From: Anita Gardner
Sent: 10 November 2015 14:35
To: Planning.Responses
Subject: FW: WA/60/15/HH - 6 Nash Way

Please find attached the revised plans. The front wall has been set back 1m and the front roof has been changed to match the ridge height of the rear roof, this lowers the ridge to nearly 1m. I think this would be a better option than changing the pitch or adding a flat roof. With regards to the verge overhang, the existing ground floor side wall is already at least 250mm away from the boundary line therefore I haven't moved it in on the side.

I have discussed the revised plans with my Team Leader. The reduction in ridge height and offset do not go far enough to make the application acceptable. The extension still does not appear subservient and requires further reduction in its overall size. I would suggest that the ridge height is set at least 1.5m below the current ridge line and that it is set back at least a metre from the front elevation. It would also benefit from a 1m gap being provided from the roof to the boundary and a reduction in depth of the extension. The amount of proposed accommodation will need to be rationalised.

## Proposed Elevations

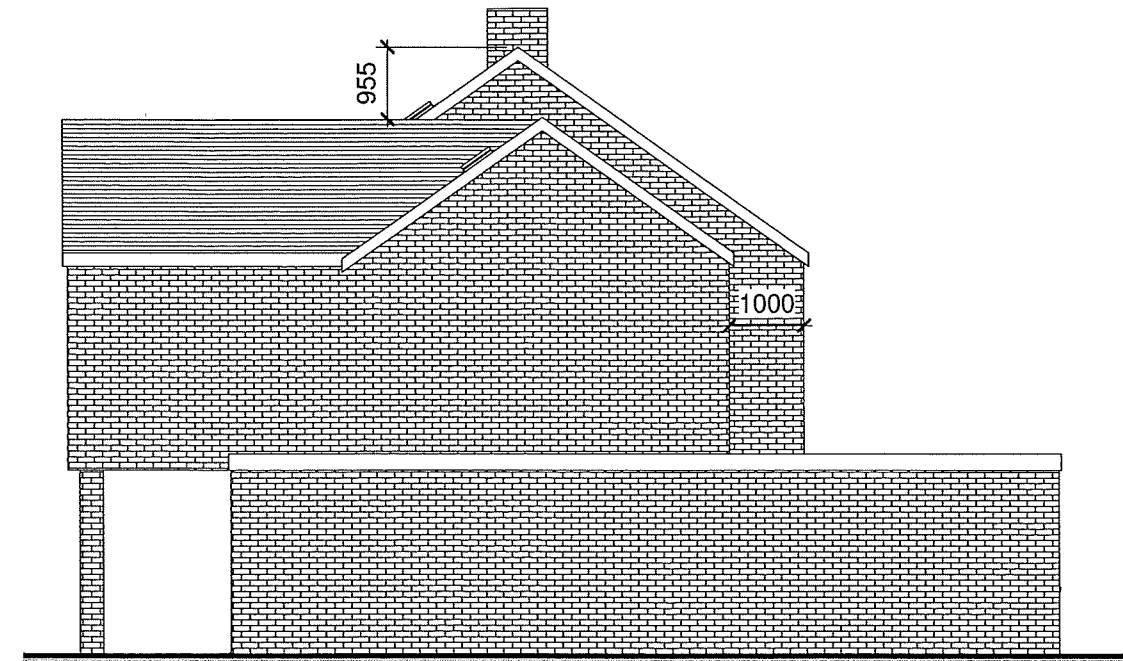
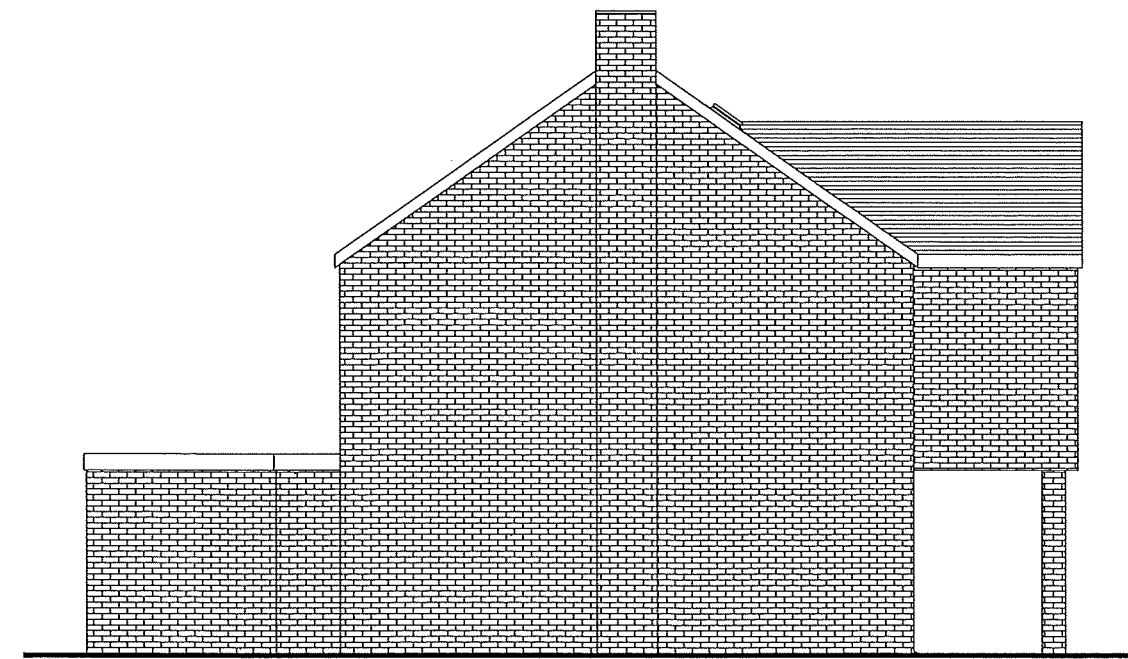
My initial comments are that I do still have concerns over the size of the extension, I don't consider the ridge height has been reduced sufficiently or that it has been set back an acceptable amount from the front elevation but I haven't yet had the opportunity to discuss the current plans with my Team Leader before I come back to you. I won't refuse the application without allowing you the opportunity to amend the scheme. I should be able to let you have my views on the extension by the end of the week.
